Response to Submissions

St Aloysius College

State Significant Development Application SSDA 8669

29 Burton Street, Kirribilli
1-5 Jeffreys Street, Kirribilli
47 Upper Pitt Street, Kirribilli

1 North Elevation - Upper Pitt Street
Scale: 1:200

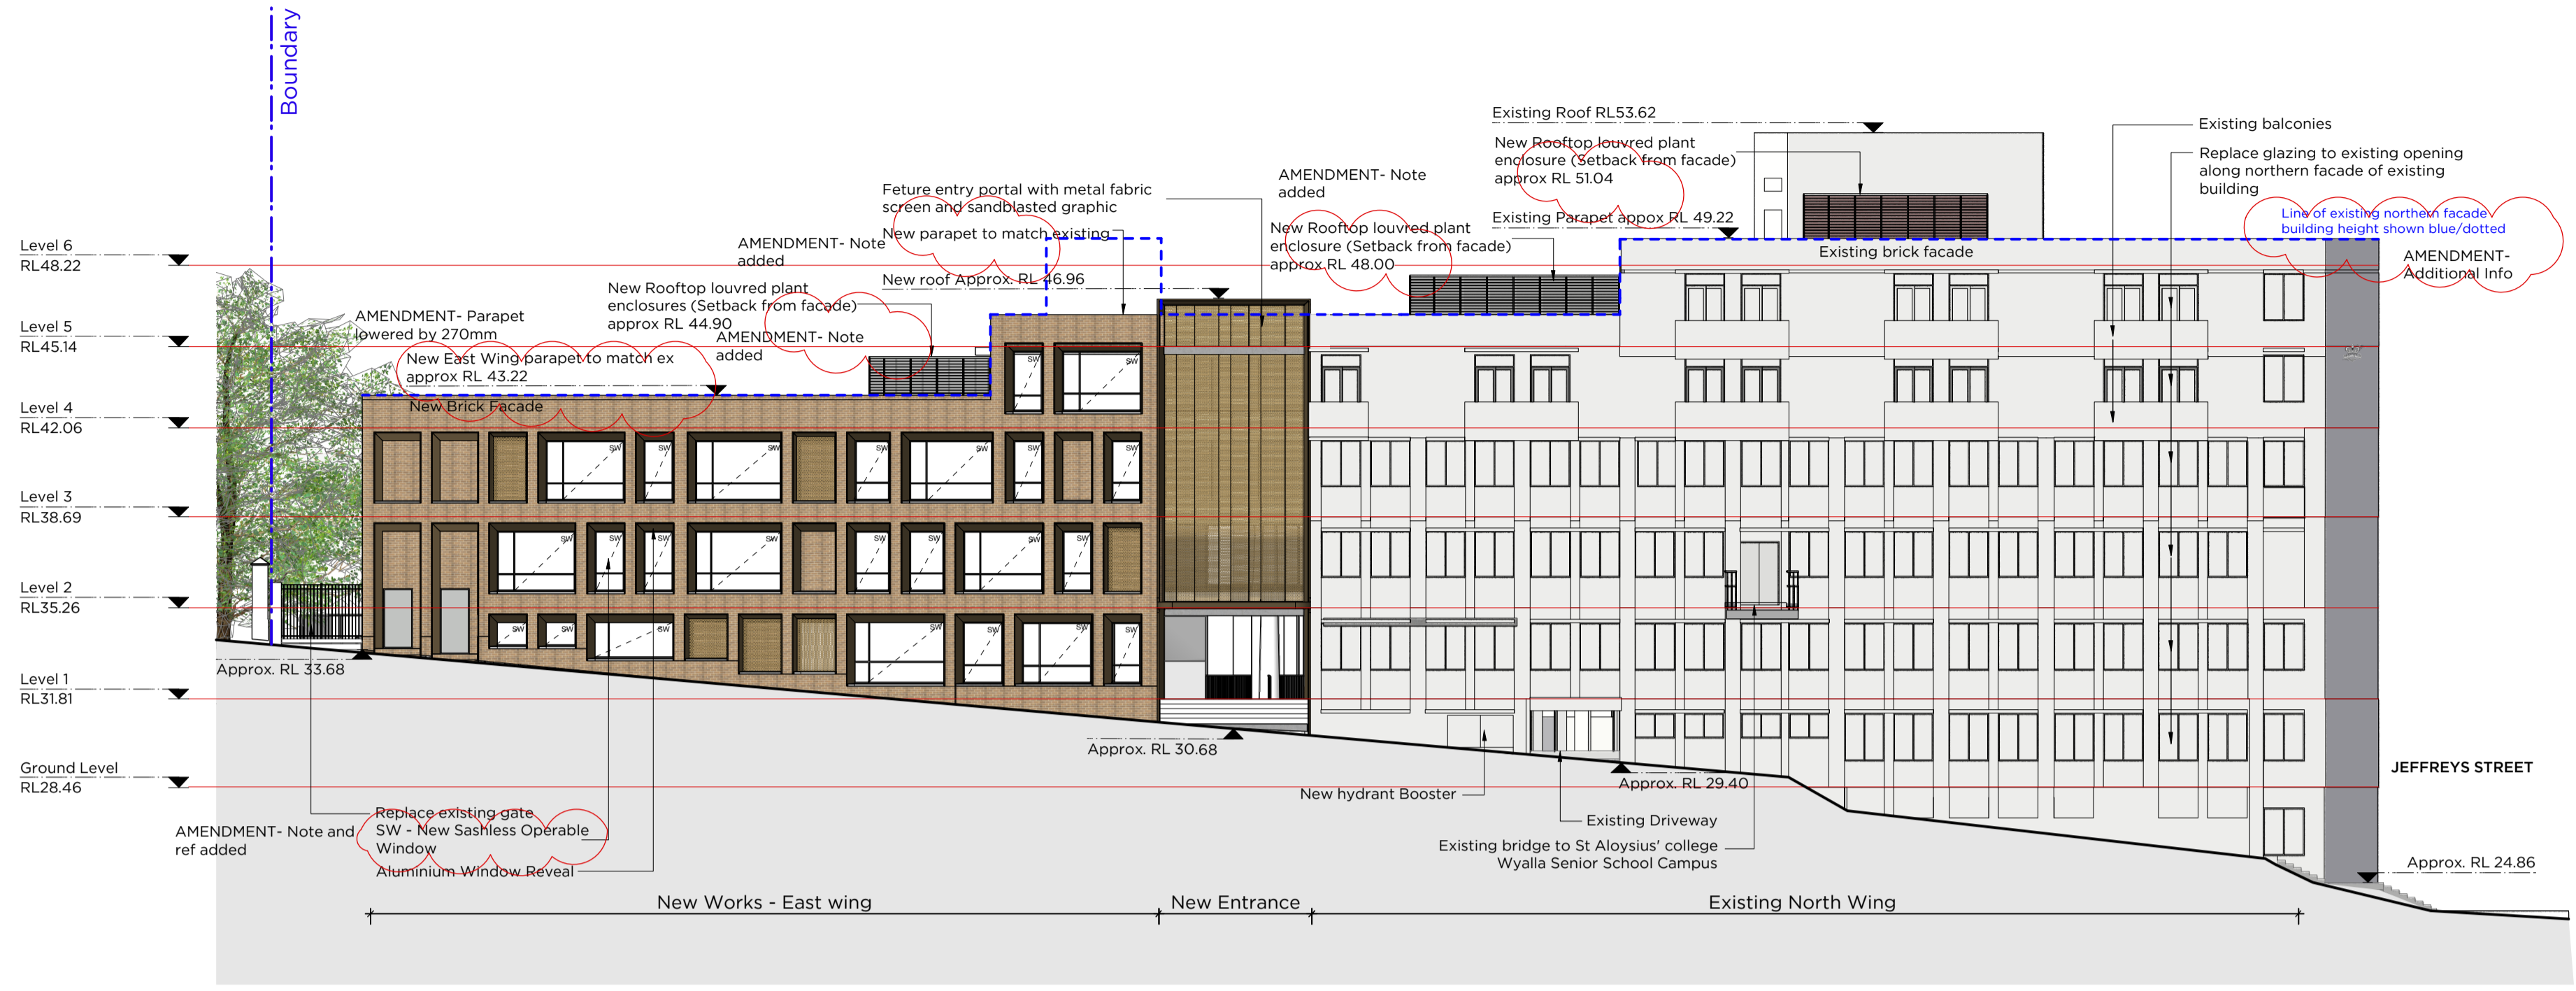
- The proposed north east wing of the Main Campus, which exceeds the permissible height limit and has adverse impacts on views currently enjoyed by the residents of both 48 Upper Pitt Street and 49 Upper Pitt Street;

- The scale of the new buildings, particularly the new additions to the Main Campus, located close to the adjoining boundary are incompatible with the built form of the adjoining property to the east.

In addition, in light of the submissions received, the parapet height of the North-East Wing was reduced **270mm**. to retain the existing building height fronting Upper Pitt Street.

2 East Elevation
Scale: 1:200

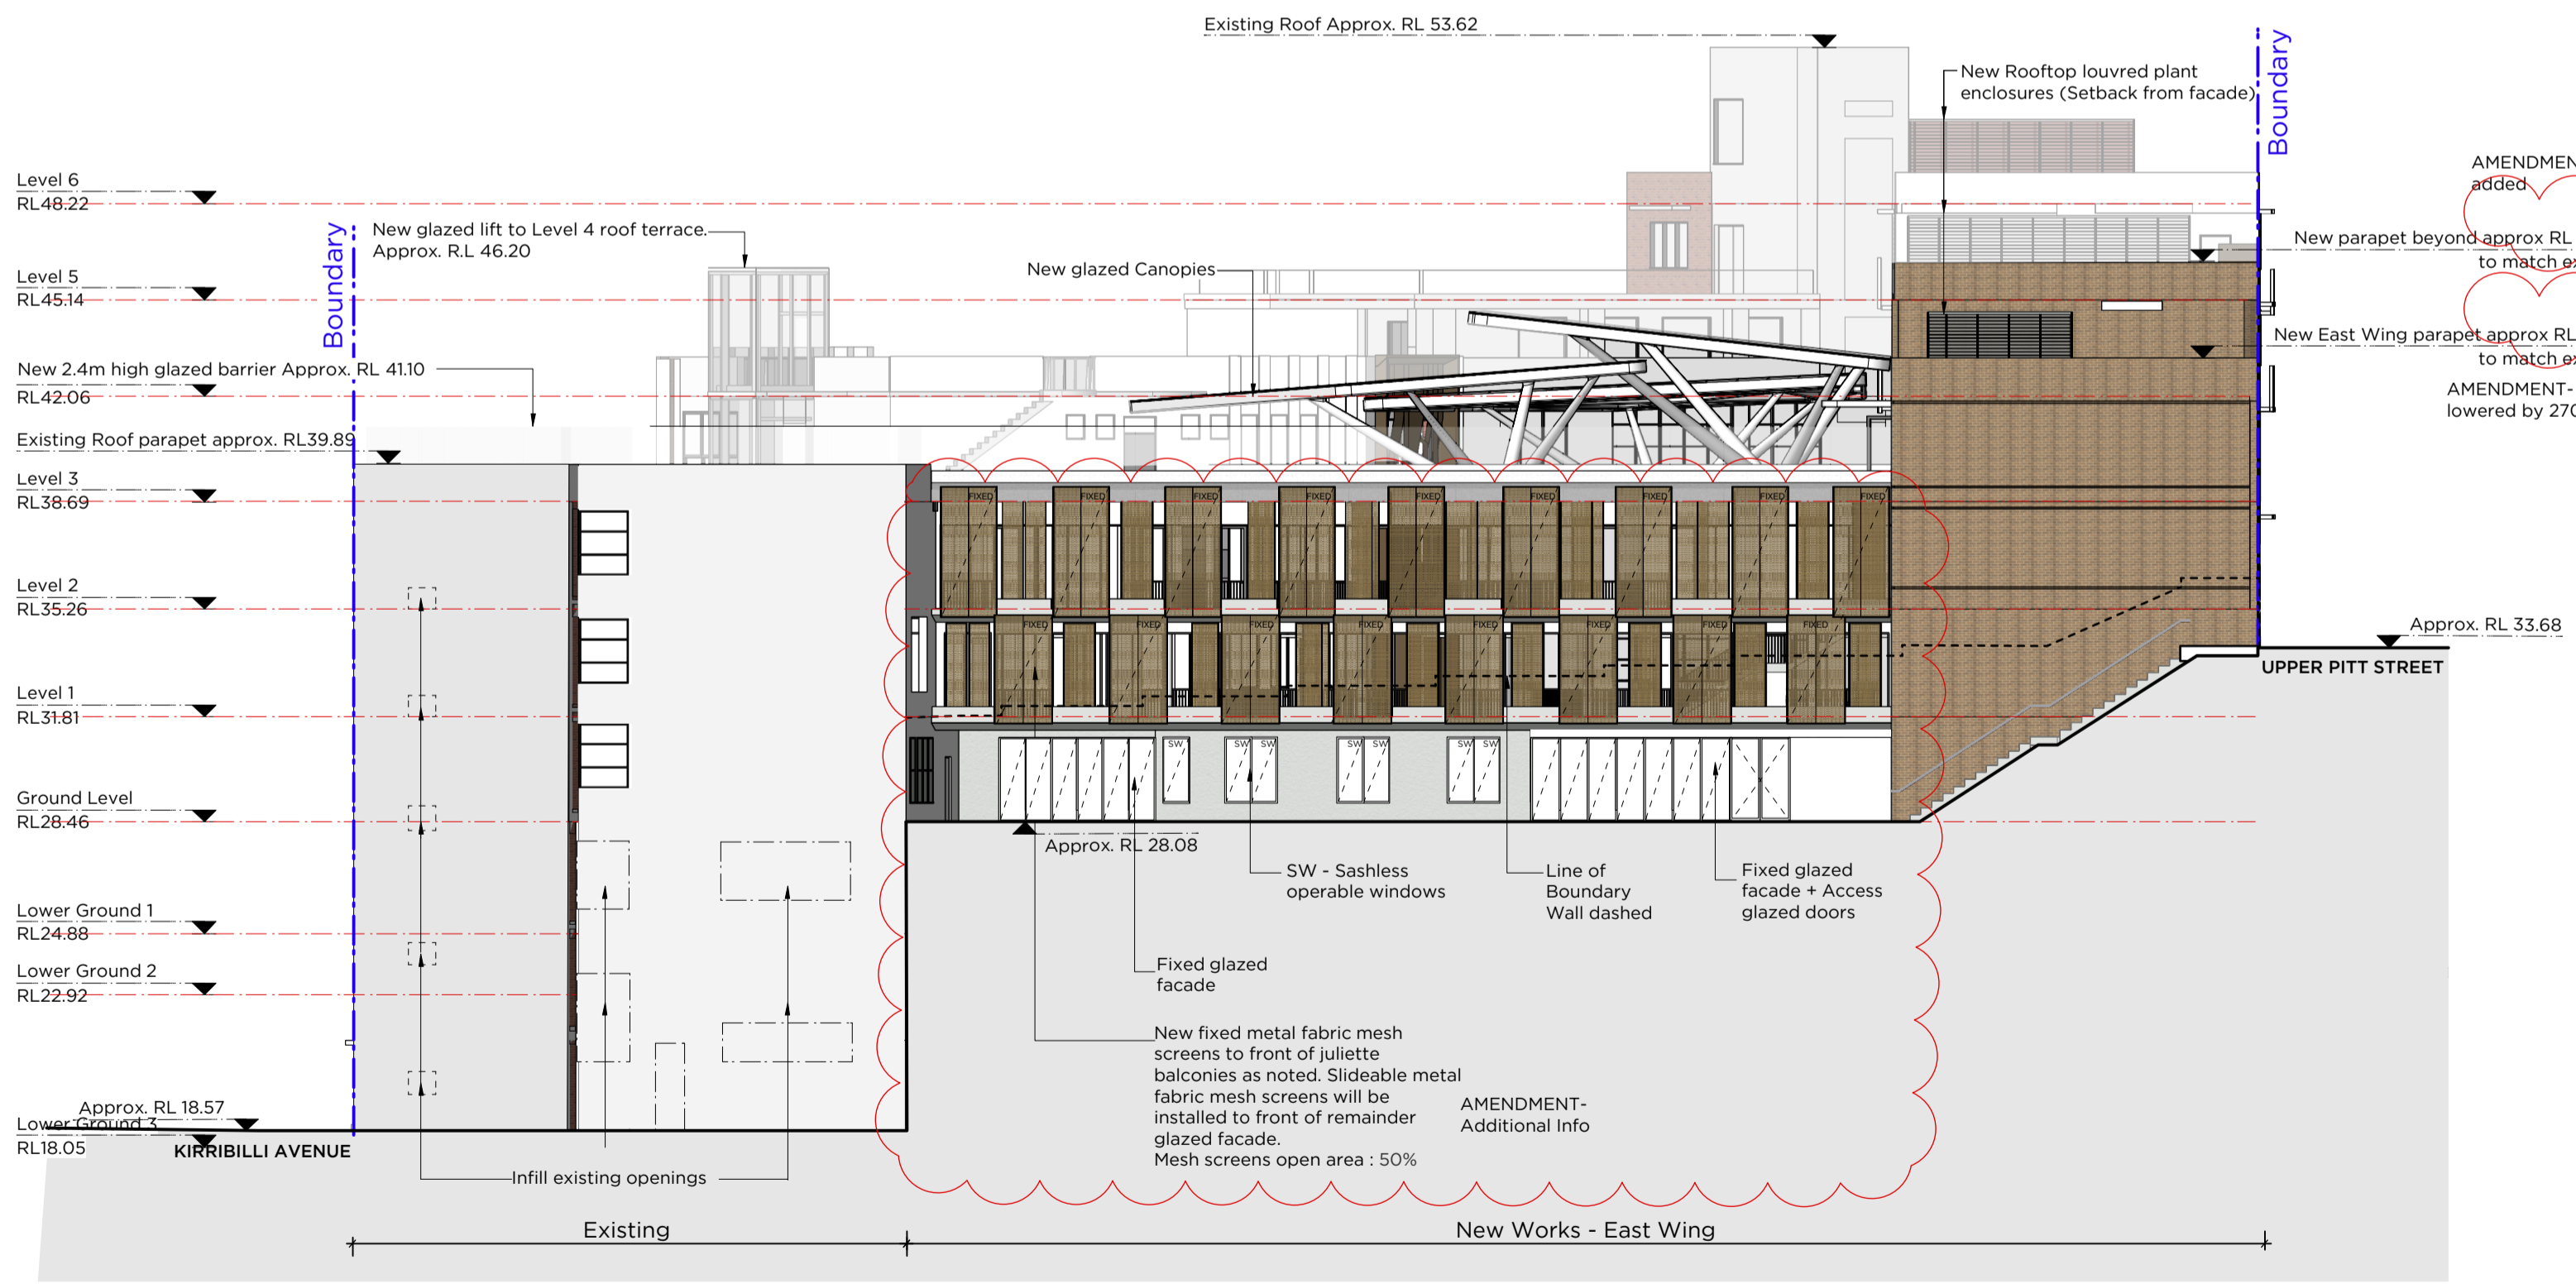
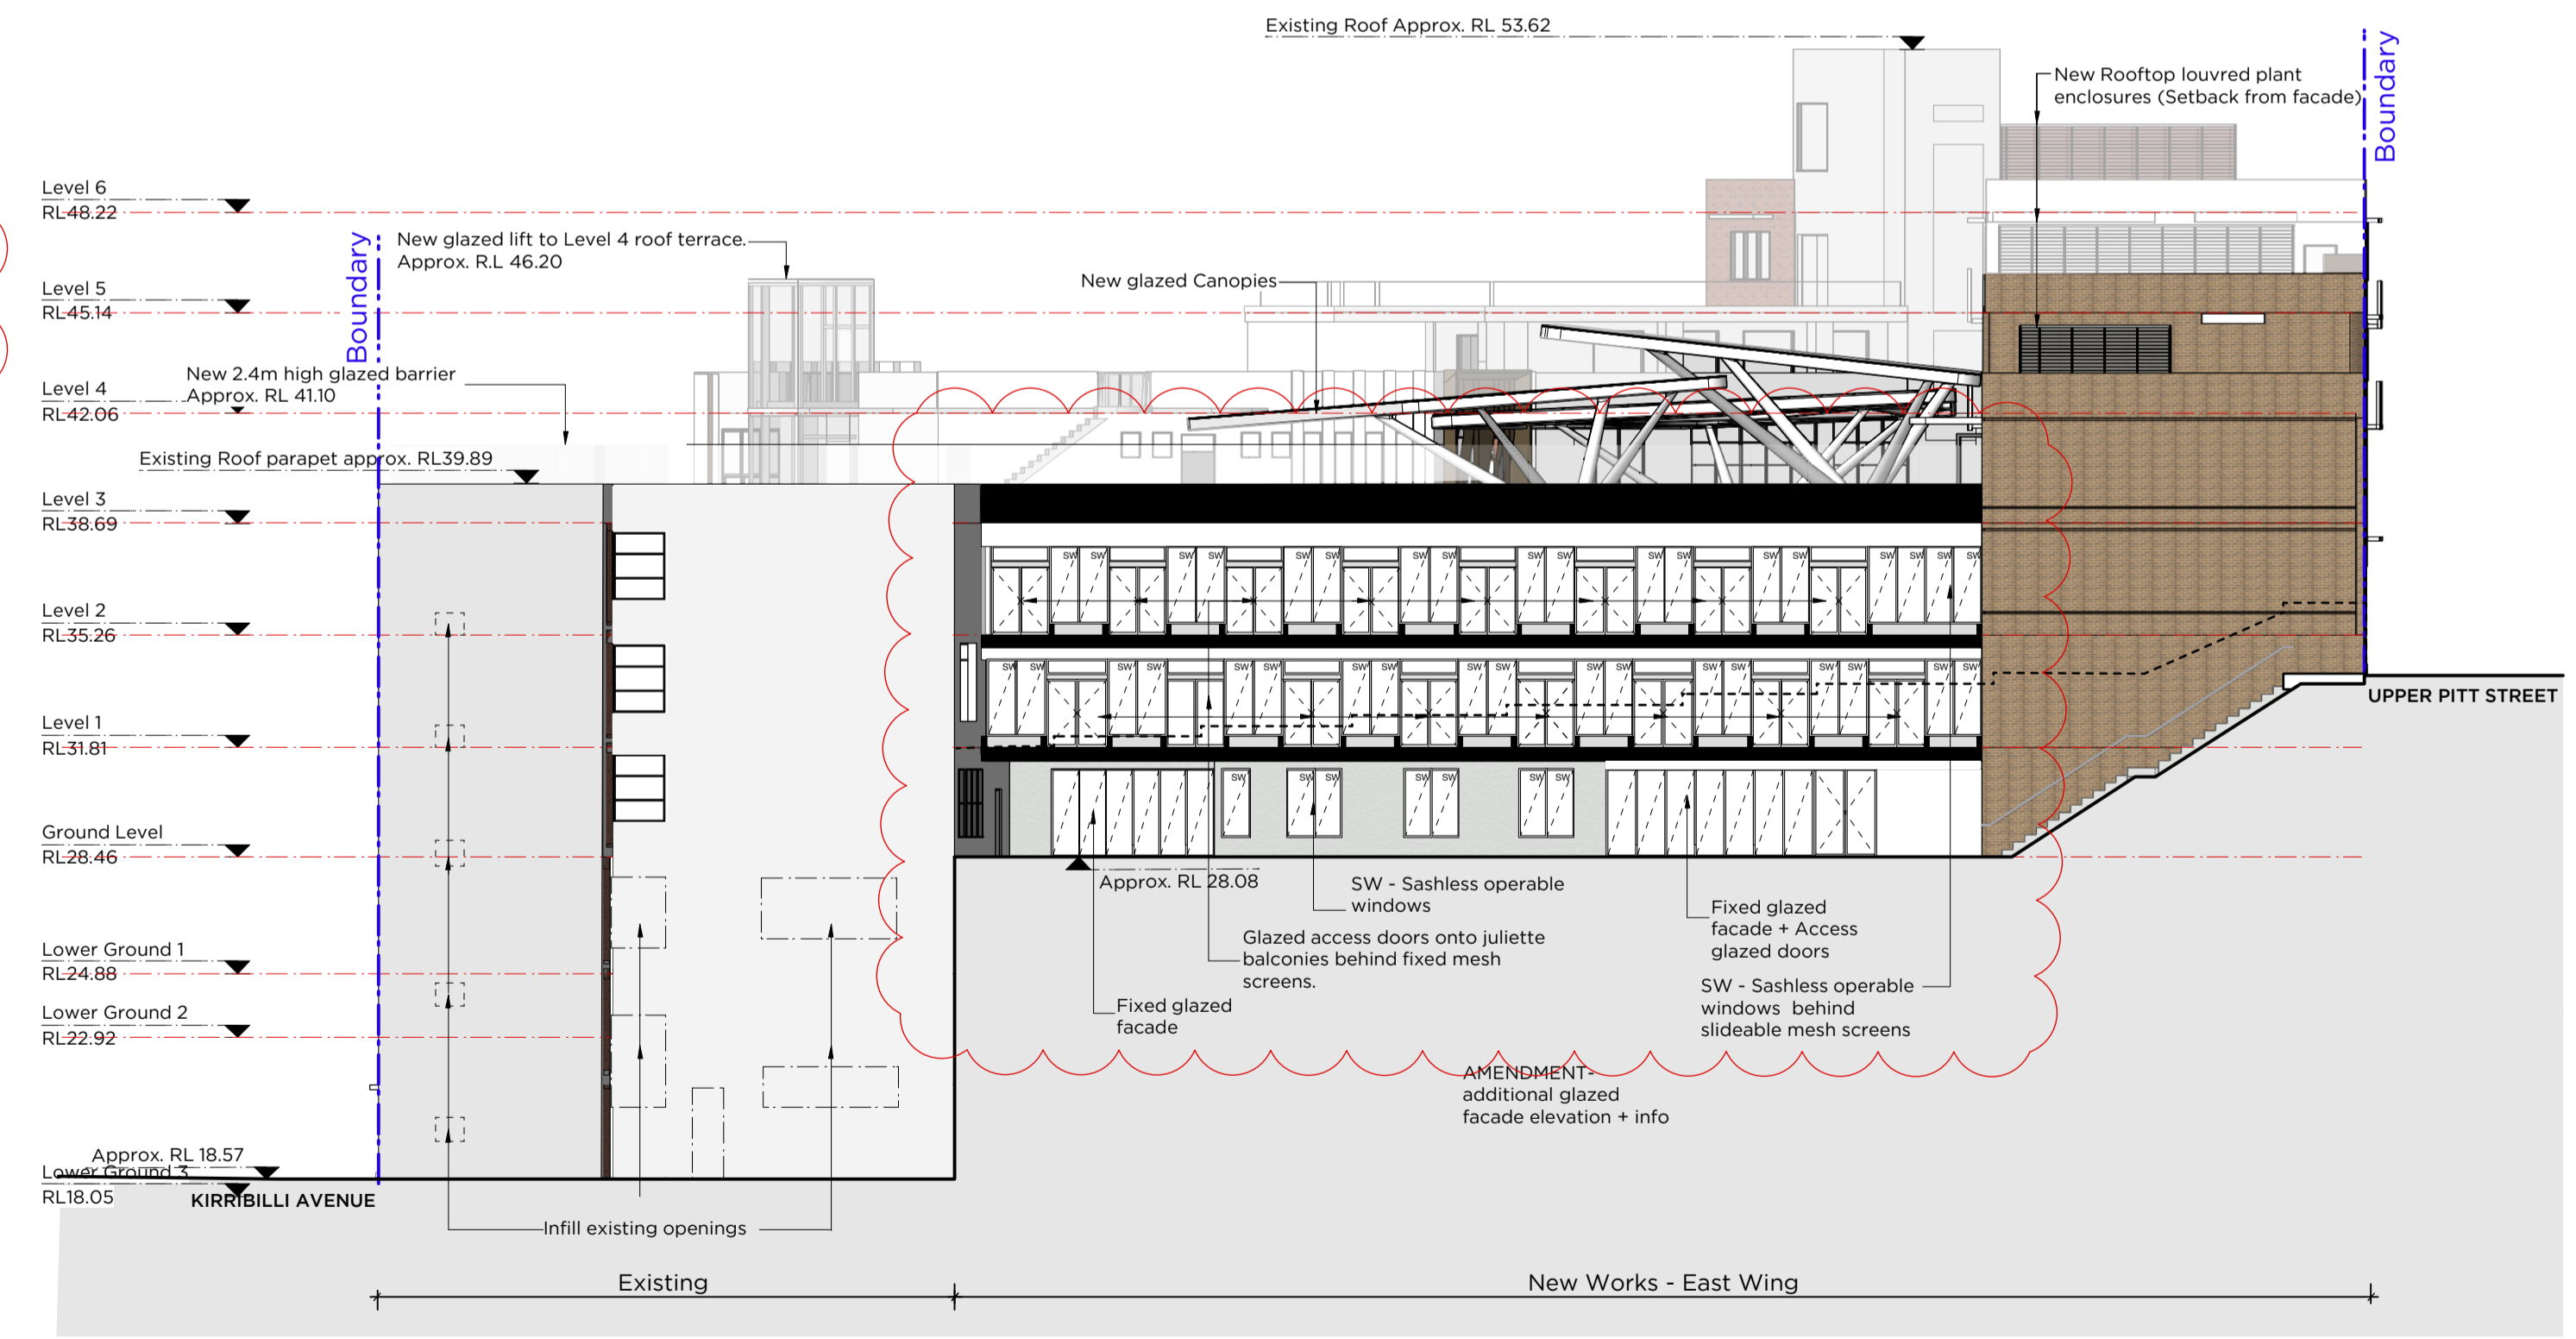
- Confirmation to be provided that the Visual Impact Assessment (VIA) and Solar Impact Analysis (SIA) have had regard to the proposed landscaping of the rooftop terrace and structural elements, including the 2.4m high acoustic barrier.

With respect to compliance with the DCP setback controls, Clause 11 of *State Environmental Planning Policy (State and Regional Development) 2011* expressly states the DCPs do not apply to SSD applications. Notwithstanding, a setback of 3.05m – 4m is provided to the eastern boundary in accordance with **Part 3.3.6** of the *North Sydney Development Control Plan 2013* (NSDCP 2013). Whilst the proposal will seek a variation to the height plane control under NSDCP 2013, this non-compliance does not contribute to the loss of views or solar access from the adjoining apartments to the east. It is not feasible to setback the building further from the eastern boundary due to the need to provide the required teaching and learning space, and the presence of the existing built form in the same location, providing an established building envelope.
